NSW RURAL FIRE SERVICE

Your reference: SSD 8989
Our reference: D17/4703
8 January 2018

Request for SEARs for a New Catholic College - Kingfisher Close & 507 Medowie Road, Medowie

Landscape Plan

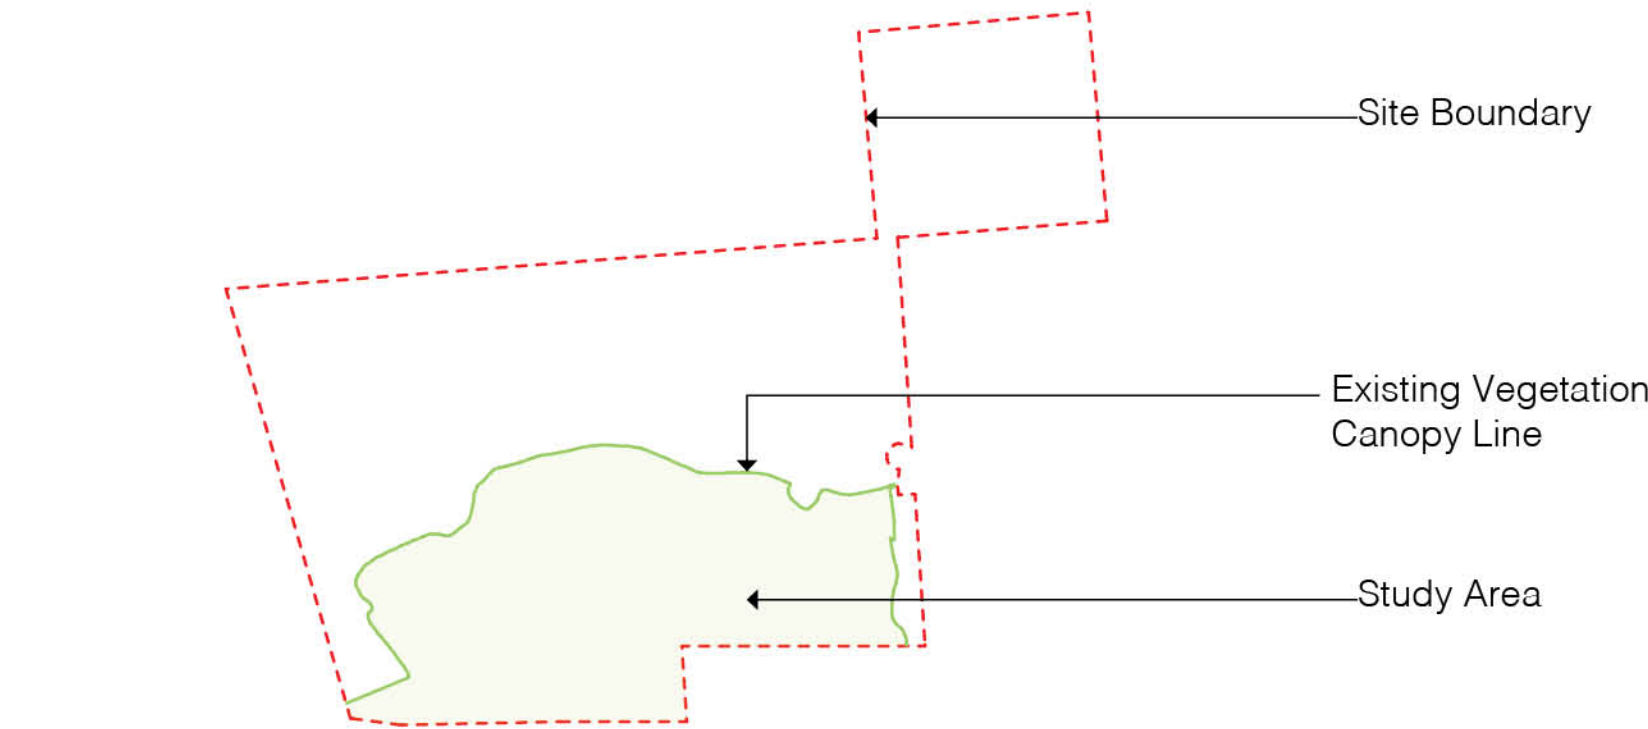
With regard to the indicate layout plan shown in the request, it is noted that a perimeter road has not been shown around the proposed school buildings. It is strongly recommended that one be incorporated in the early design phase in order to achieve compliance with *Planning for Bush Fire Protection 2006*.
